Thank you for the opportunity to comment on SSD -10446 for the Advanced Resource Recovery Centre (ARRC) at (Lot 3) 275 Adams Road, Luddenham.

This is a response from the Western Sydney Planning Partnership (Planning Partnership). It is requested that the NSW Department of Planning, Industry and Environment consider the matters in **Attachment 1** when assessing the application.

Attachment 1 – Detailed comments from Planning Partnership

APPENDIX T – LANDSCAPE CONCEPT DESIGN

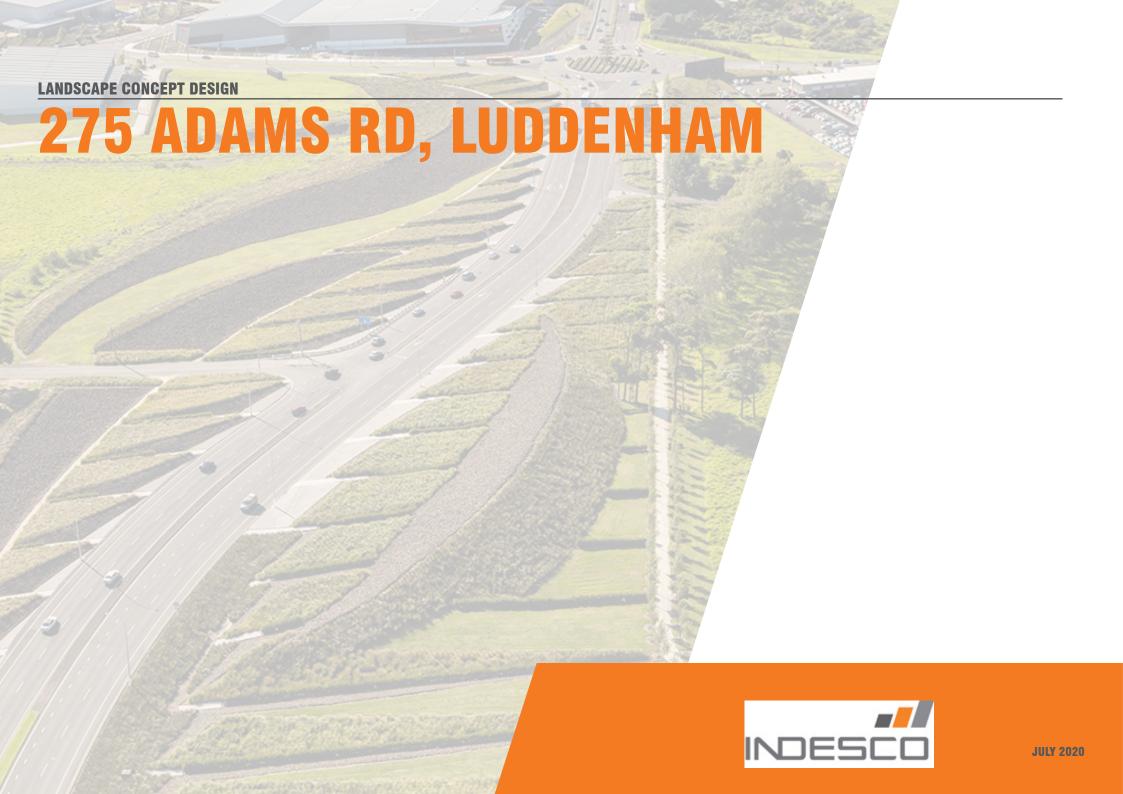
A Landscape Concept Plan is provided - Appendix T. Any landscaping species being planted should be on the proviso they do not attract wildlife or grow to a size which will penetrate the Obstacle Limitation Surface.
